Project #: 1001386

Project Name: CORONA DEL SOL SUBDIVISION

Re: DRB Sign Off of City Project Number 1001386, 13EPC-40154: Desert Hills Site  
Development Plan for Building Permit

Project# 1001386  
13EPC-40154 Site Development Plan for Building  
Permit

DRB SUBMITTAL

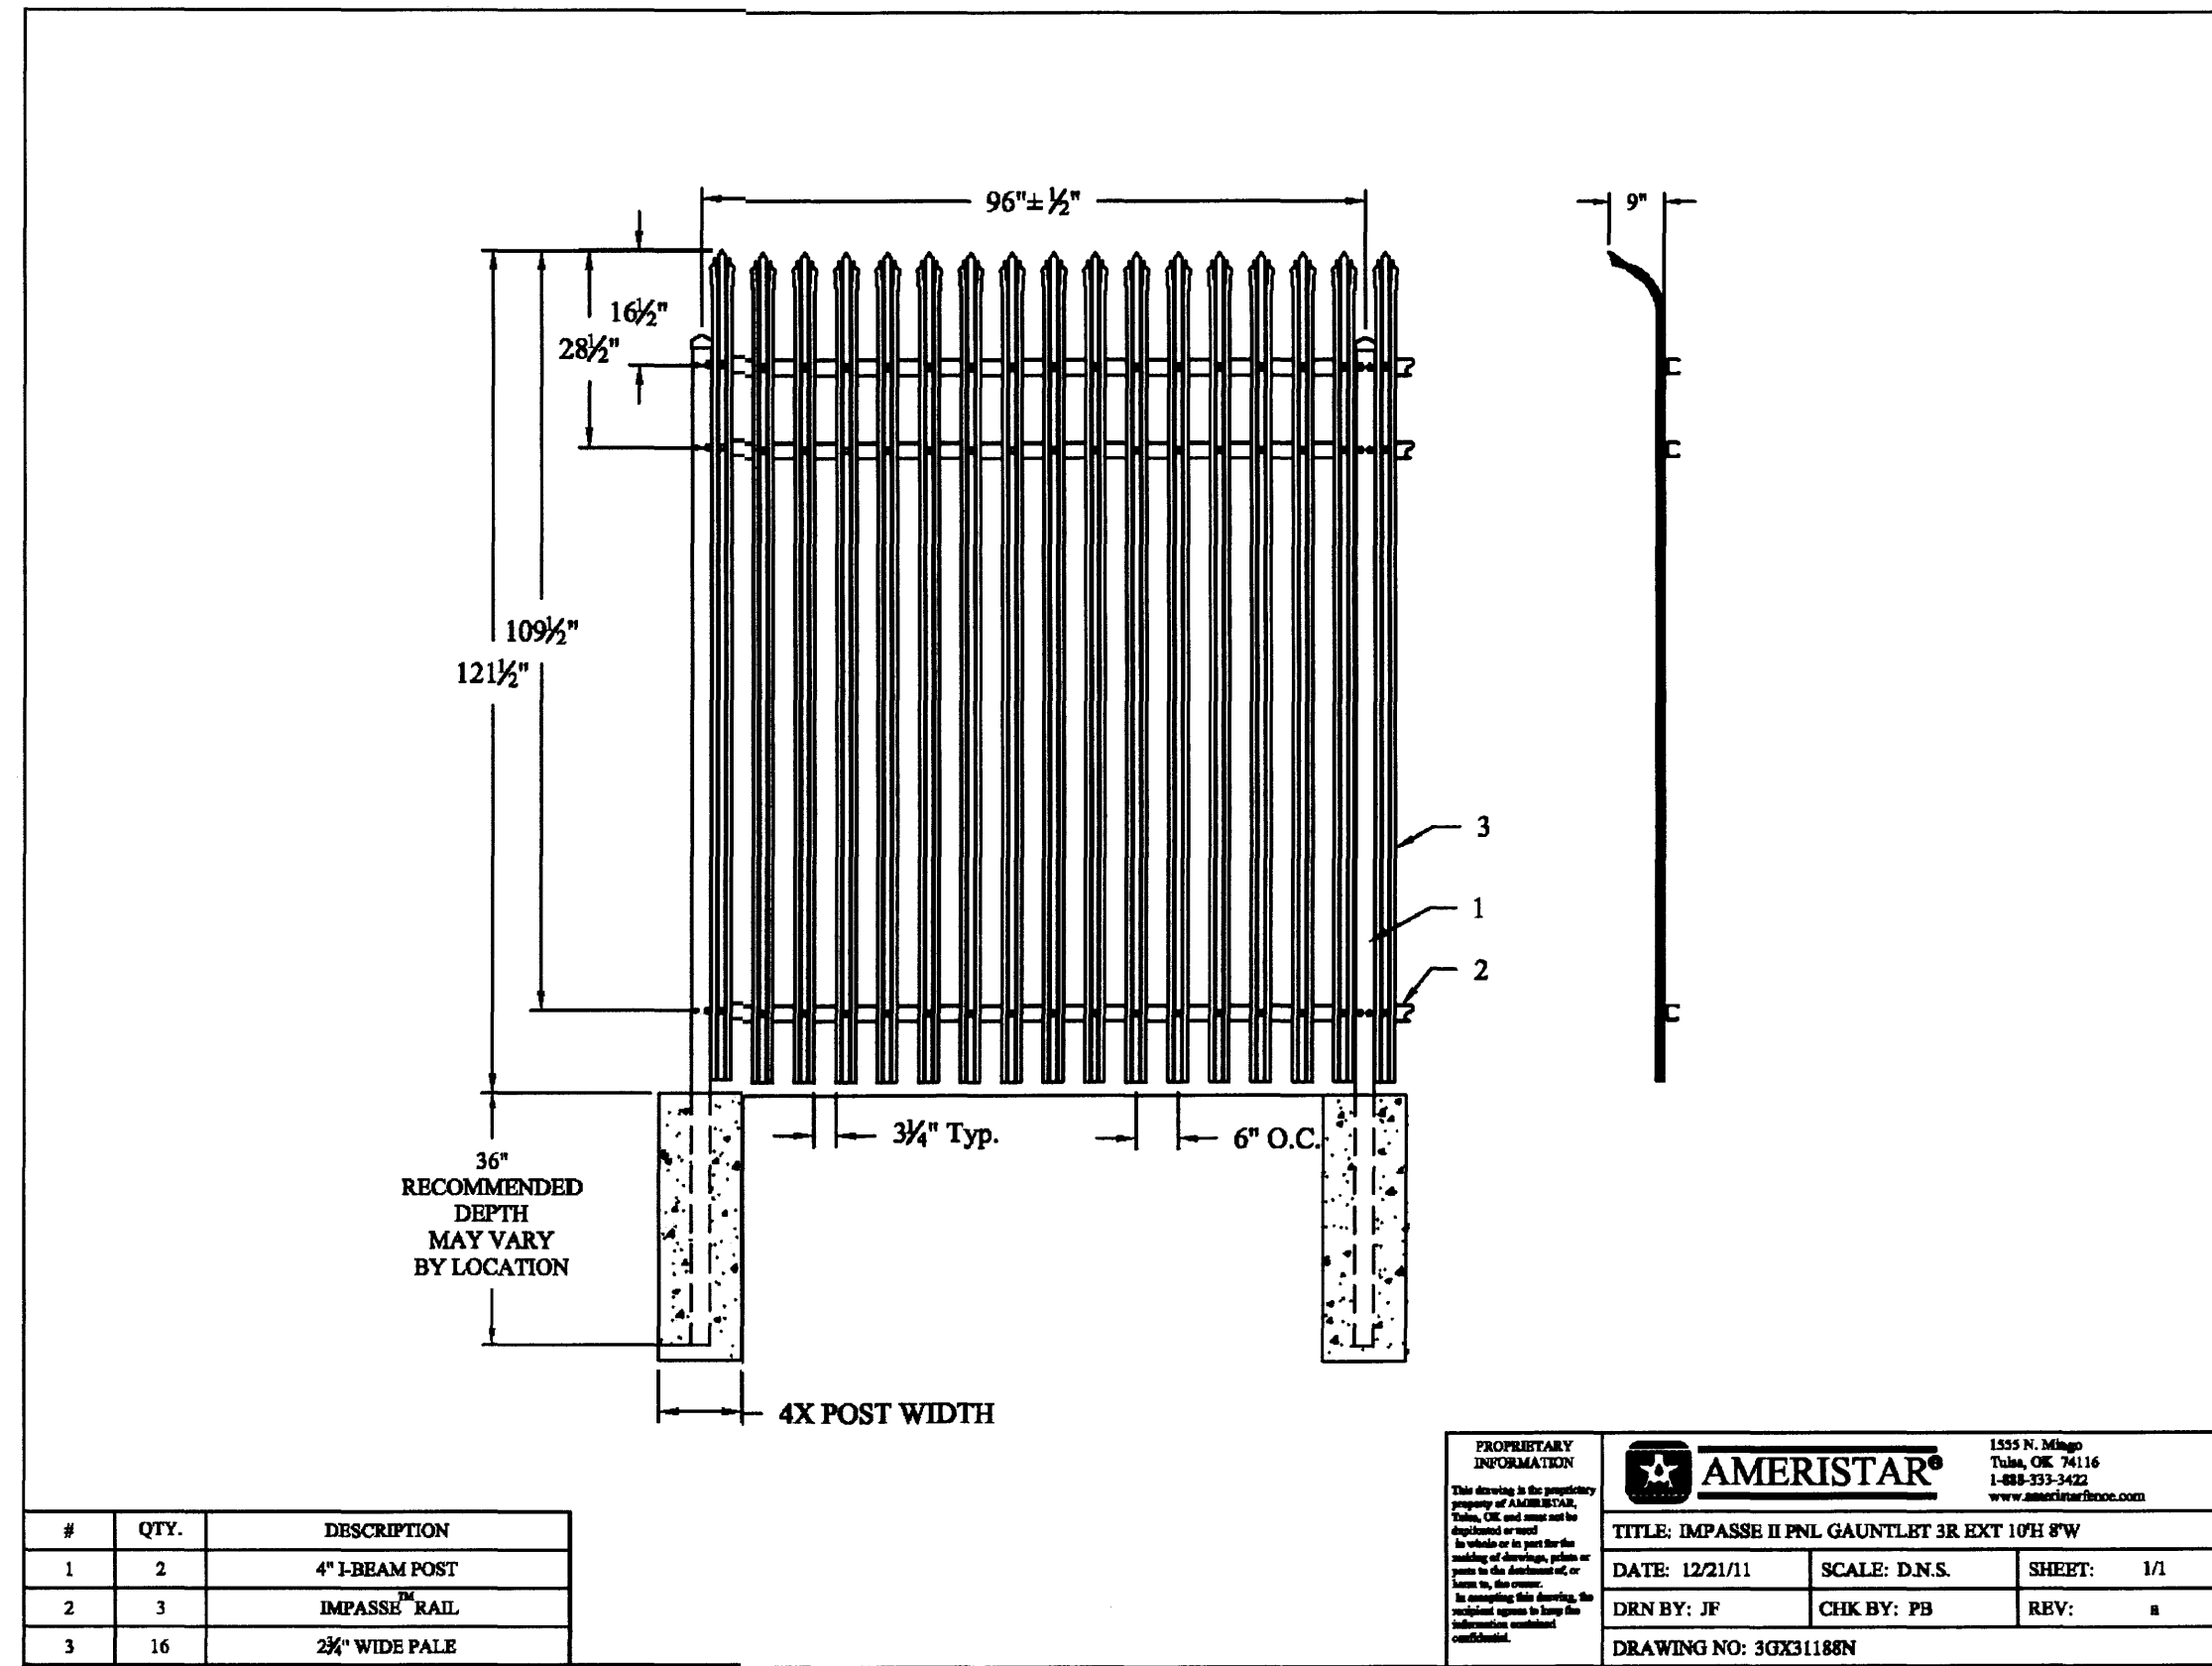
6. All requirements of previous actions taken by the EPC and/or DRB have been completed and are included as a part of this submittal.
7. Details of the perimeter fence are provided on the Site Development Plan for Building Permit Sheet C 1.1A.

8. General Note *number 7* has been added to Sheet C1.1 and General Note number 5 has been added to Sheet L1.1 as required by this condition.
9. A draft Cross Access agreement/easement between Tracts 22-A and Tract 22-B-1 is being prepared. This agreement will be filed prior to DRB final sign-off.

**C1.2**

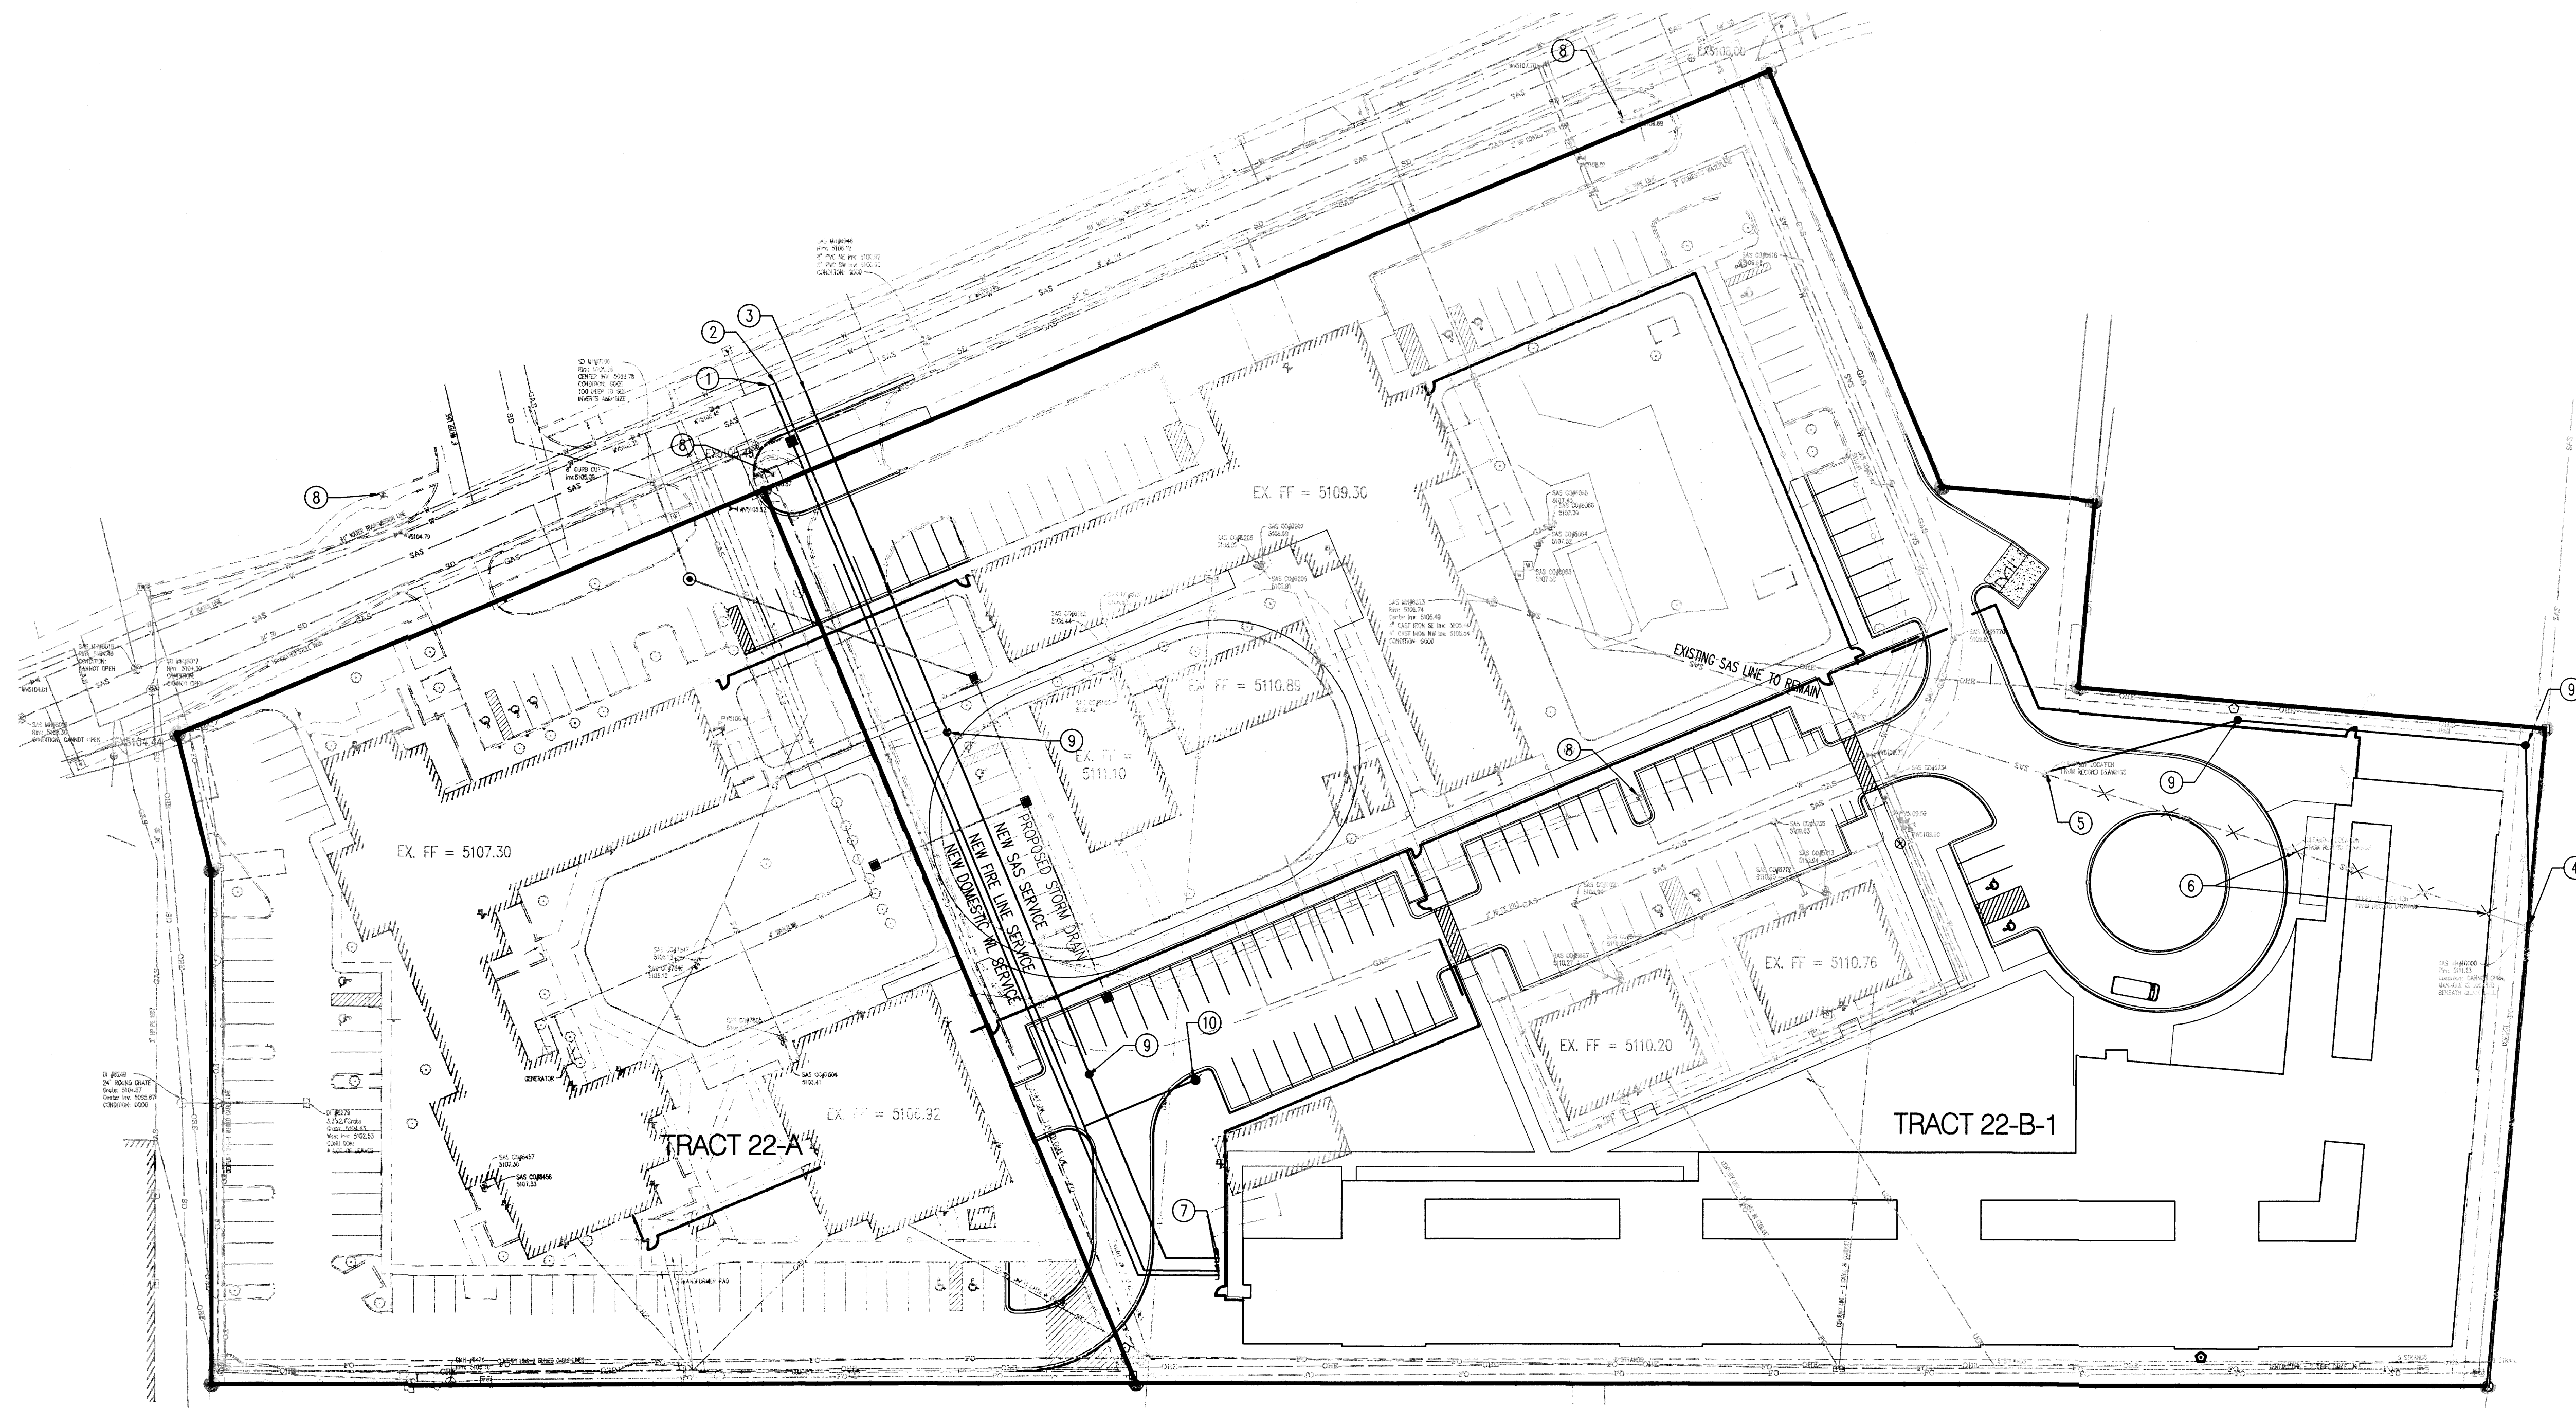
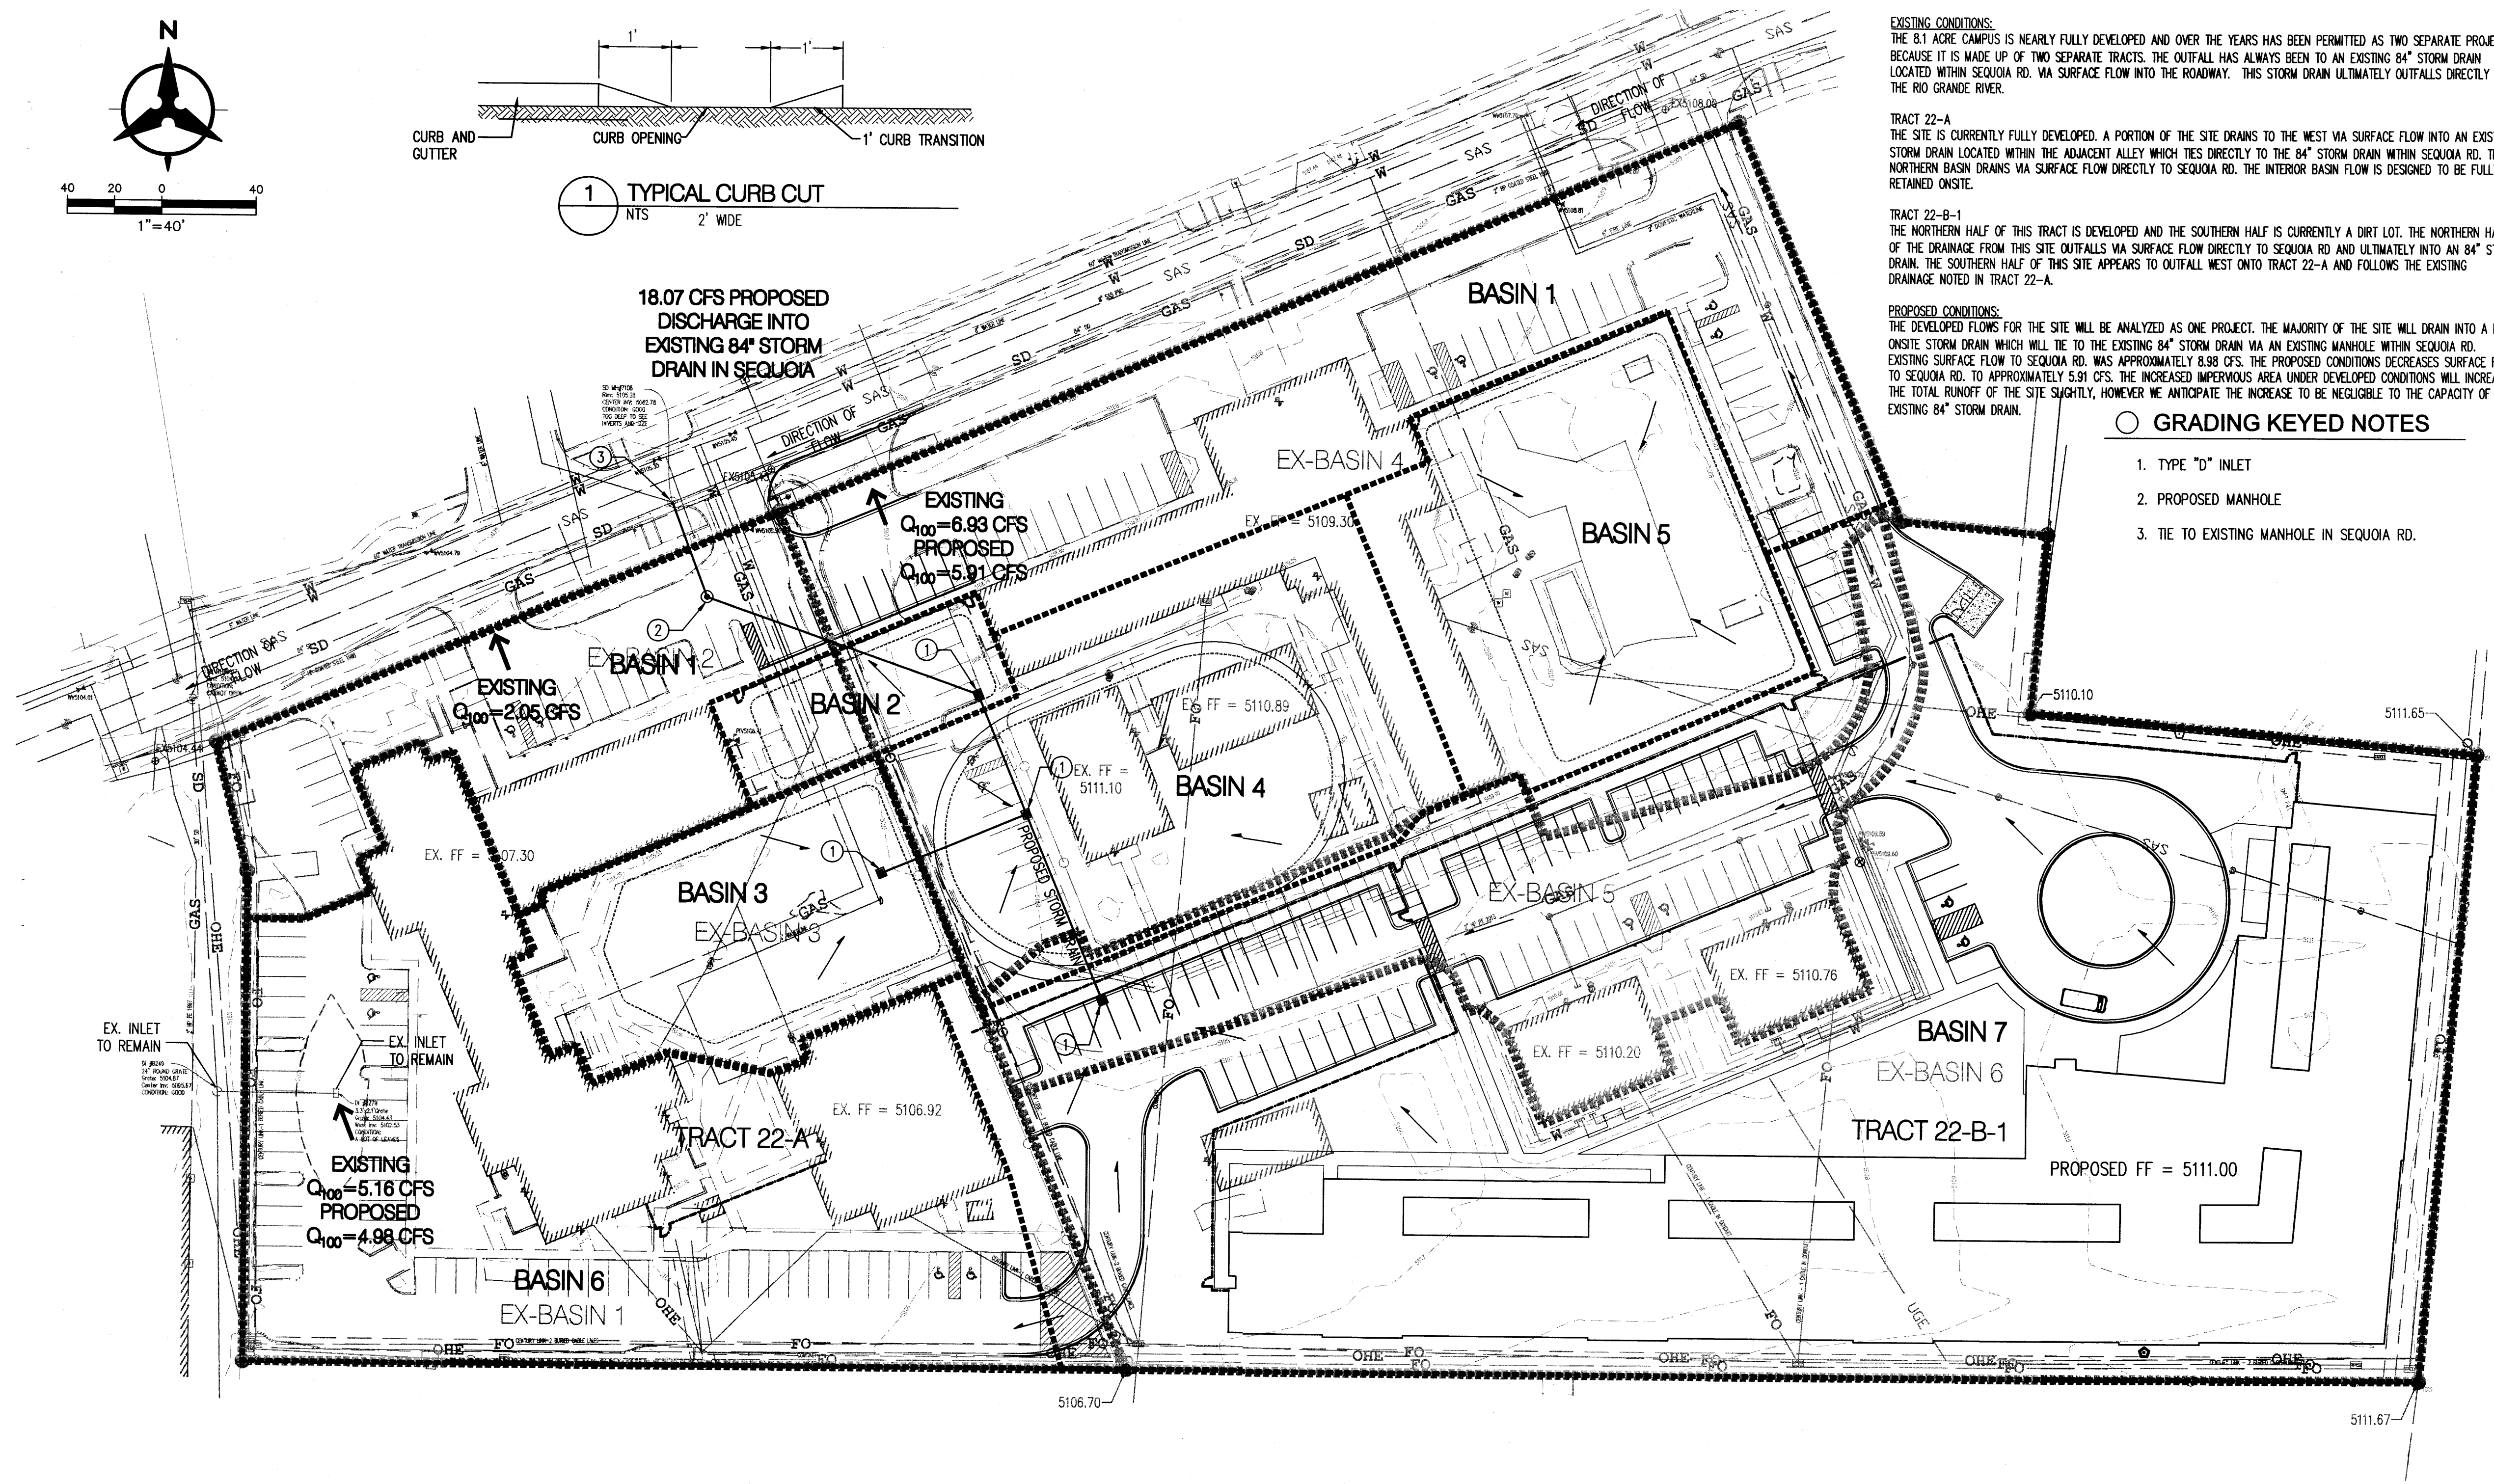
10. A meeting was held with Mr. Curtis Cherne on January 29<sup>th</sup> and additional drainage requirements have been added to the Conceptual Grading Plan, Sheet C1.2.
11. The refuse enclosure area has been relocated. A signature indicating the approval from the City Solid Waste Department has been obtained and is included with this submittal.
